WEST SUSSEX COUNTY COUNCIL CONSULTATION

TO:	Arun District Council FAO: Amber Willard
FROM:	WSCC - Highways Authority
DATE:	30 October 2019
LOCATION:	181 Chichester Road, Bognor Regis, PO21 5AF
SUBJECT:	BR/262/19/HH Pavement crossing and dropped kerb.
DATE OF SITE VISIT:	N/A
RECOMMENDATION:	Advice
S106 CONTRIBUTION TOTAL:	N/A

Title	Client
PROPOSED DROPPED KERB DETAILS	MR & MRS PETER LEE
Project	Drawn by Richard Hollands
PROPOSED PAVEMENT CROSSING AND DROPPED CURB	GROVE DESIGN UK
@ 181 CHICHESTER ROAD	Date October 2019
BOGNOR REGIS	Scale 1: 200 & 1 :500 @ A3
WEST SUSSEX	Drawing No 19-10-GD-239-02
PO21 5AF	Amendments

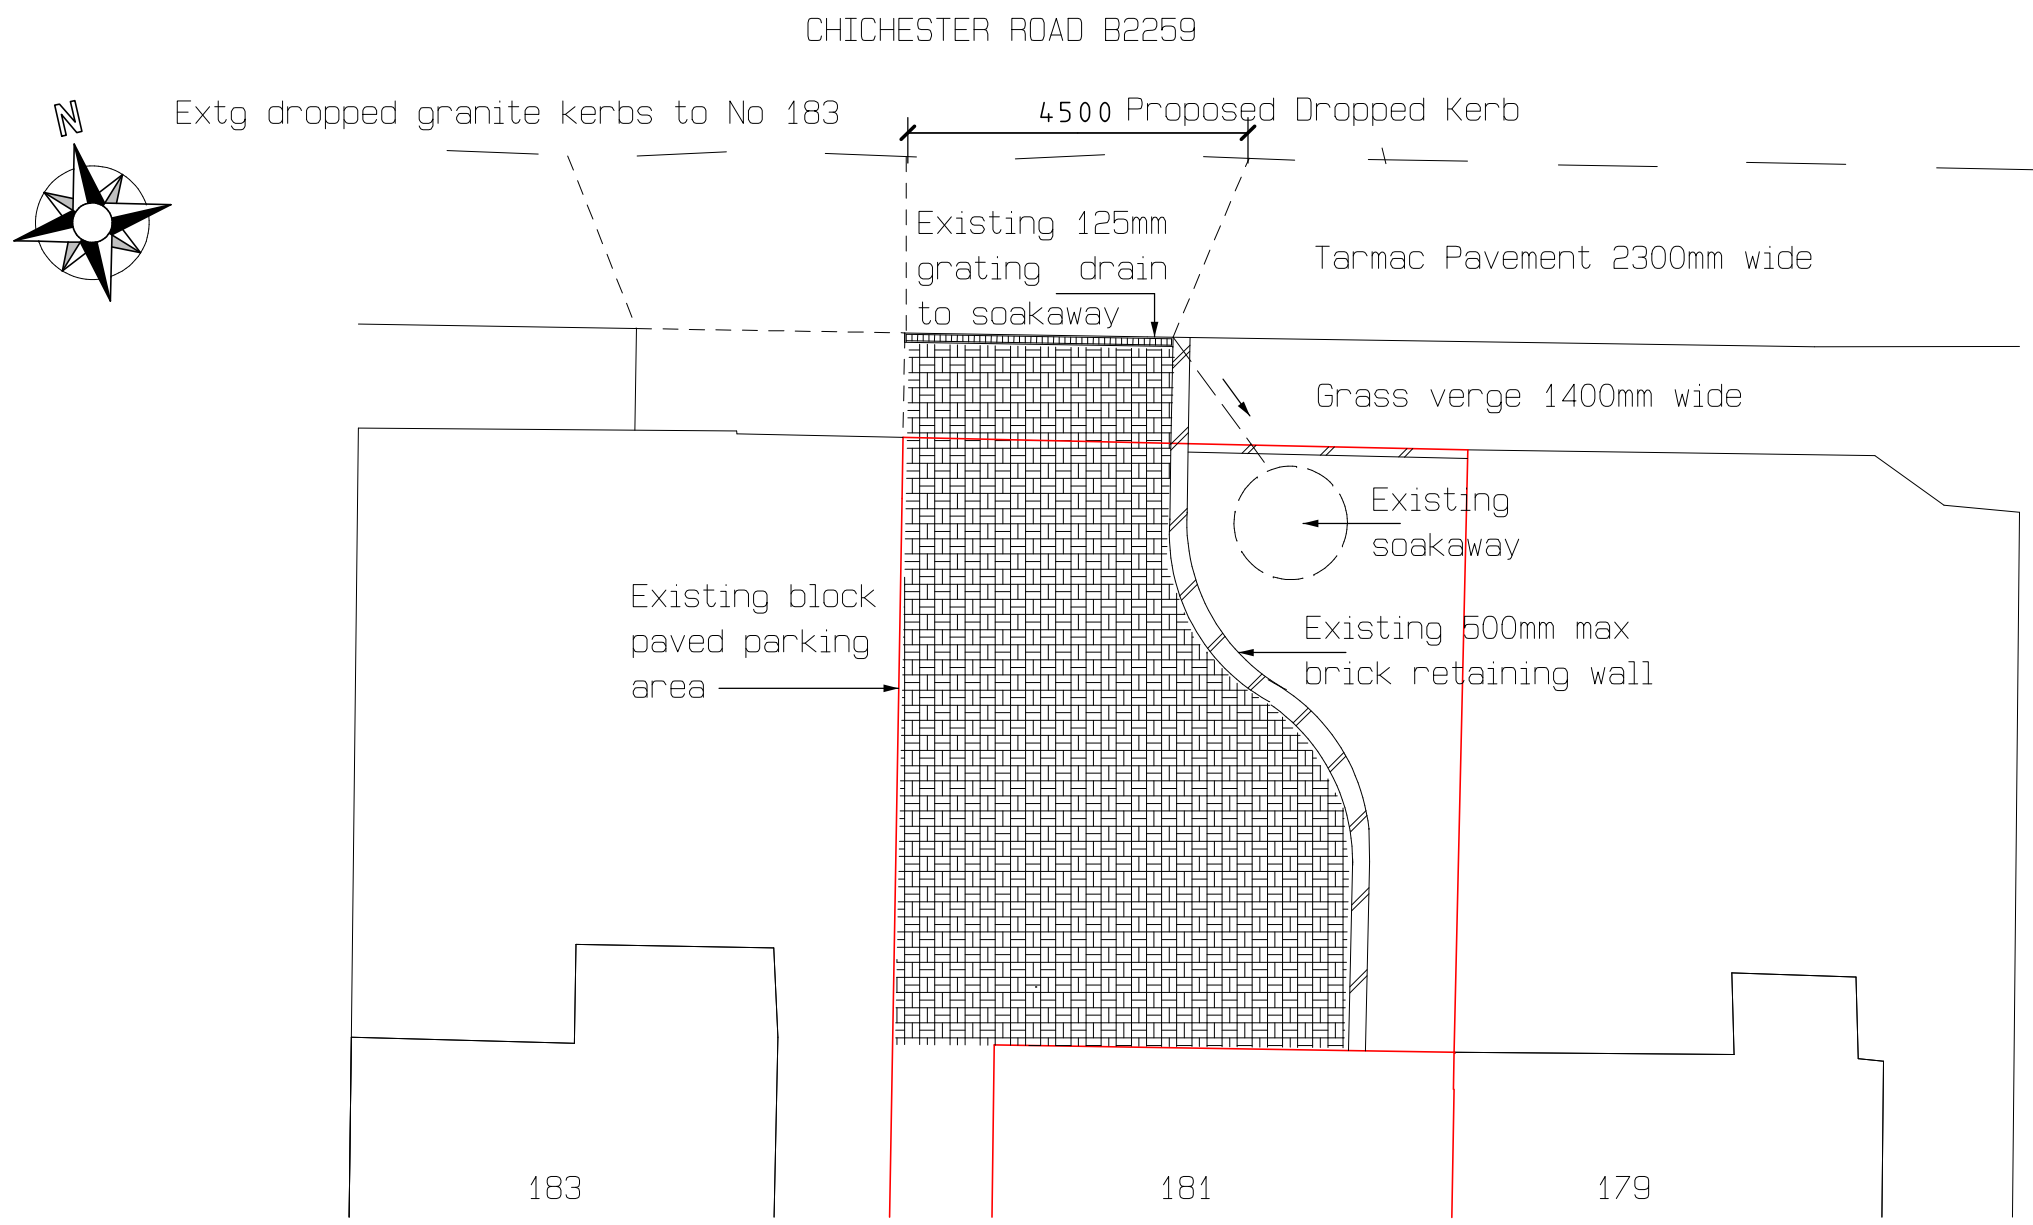
The proposed dropped kerb is to be 4.5m in width and will serve an existing block paved driveway. The dropped kerb would be subject to a licence obtained from the Local Area Office and constructed to a specification agreed with the Local Area Engineer.

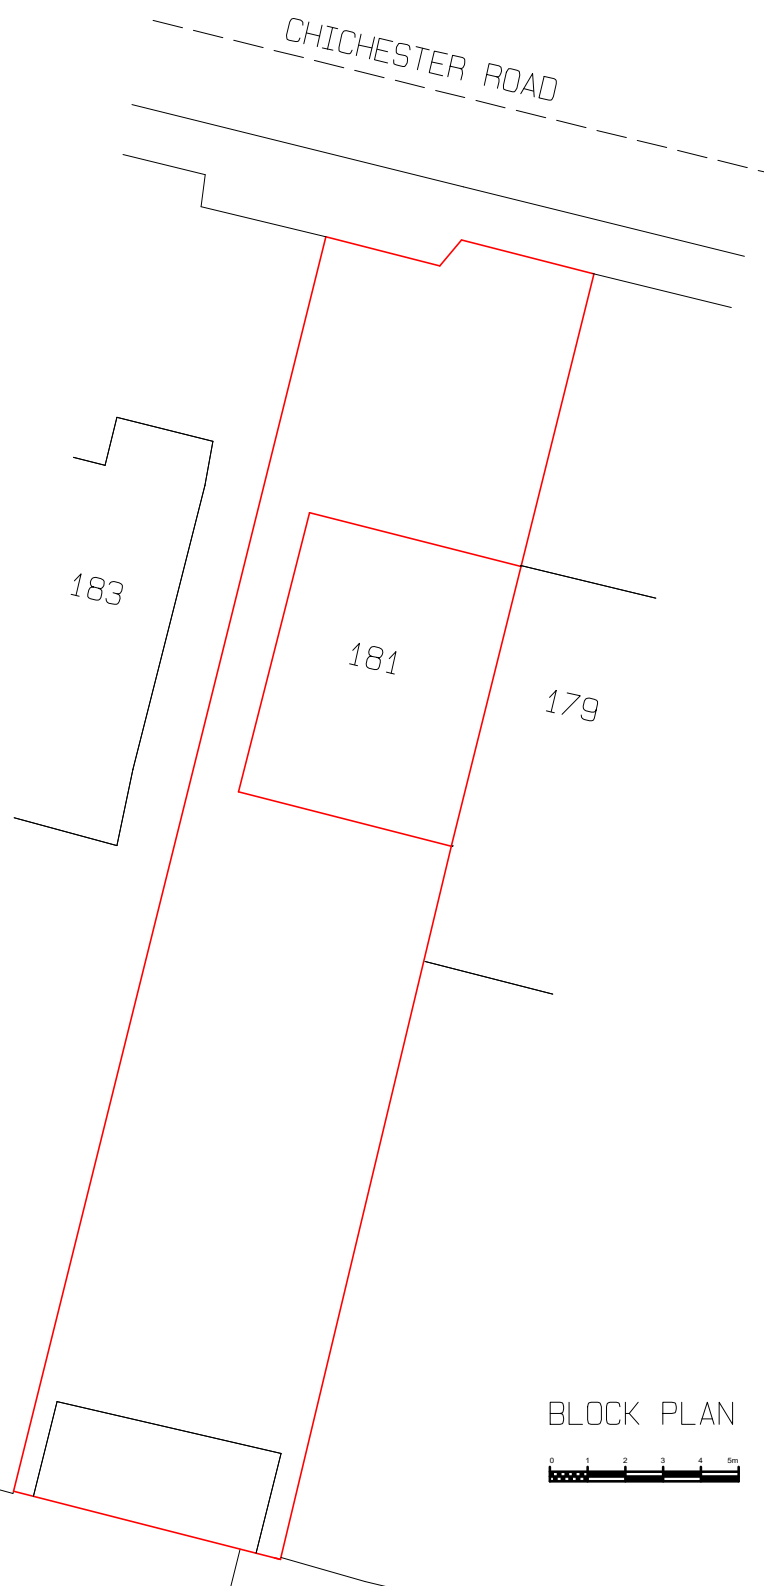
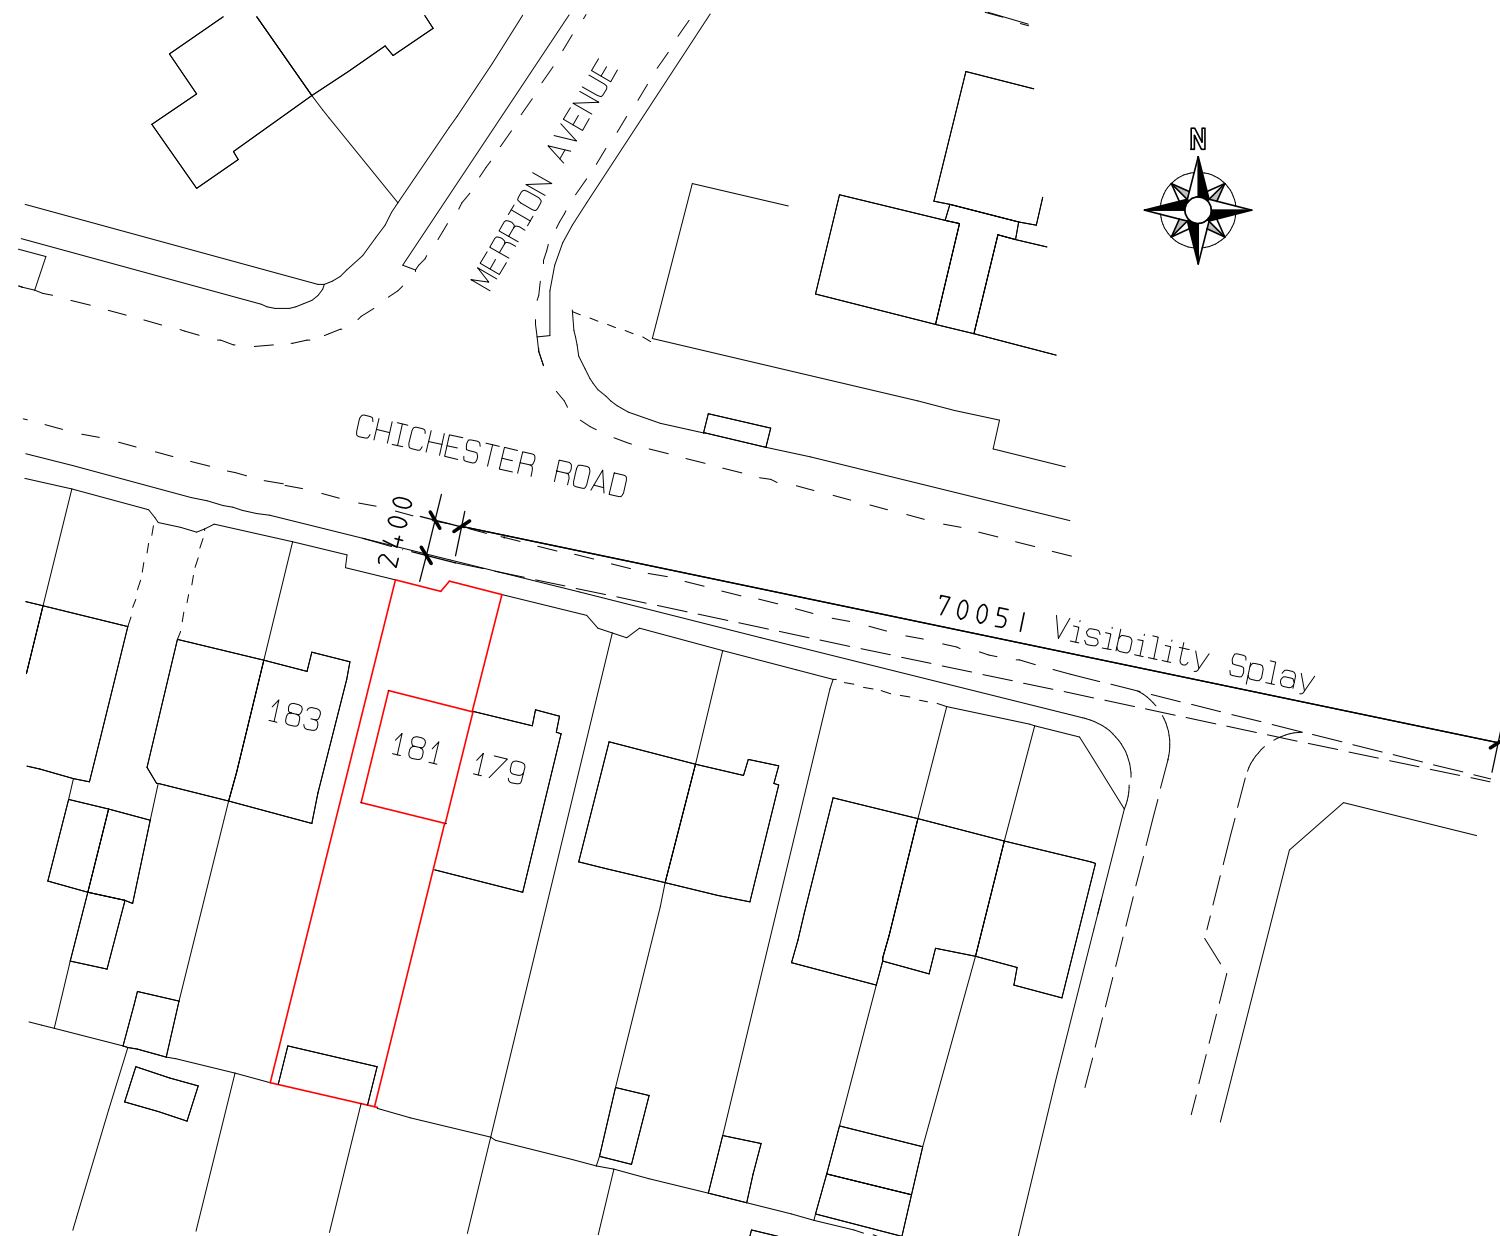
Visibility from the site onto Chichester Road appears sufficient in both directions. The driveway is of sufficient size for 1 car parking space that meets the minimum specifications for single car bays of 2.4m x 4.8m as set out in Manual for Streets (MfS).

On-site turning will not be achievable, so vehicles may have to exit the site in a reverse gear. However, Chichester Road has good forward visibility and neighbouring properties appear to operate similar arrangements with no known safety concerns.
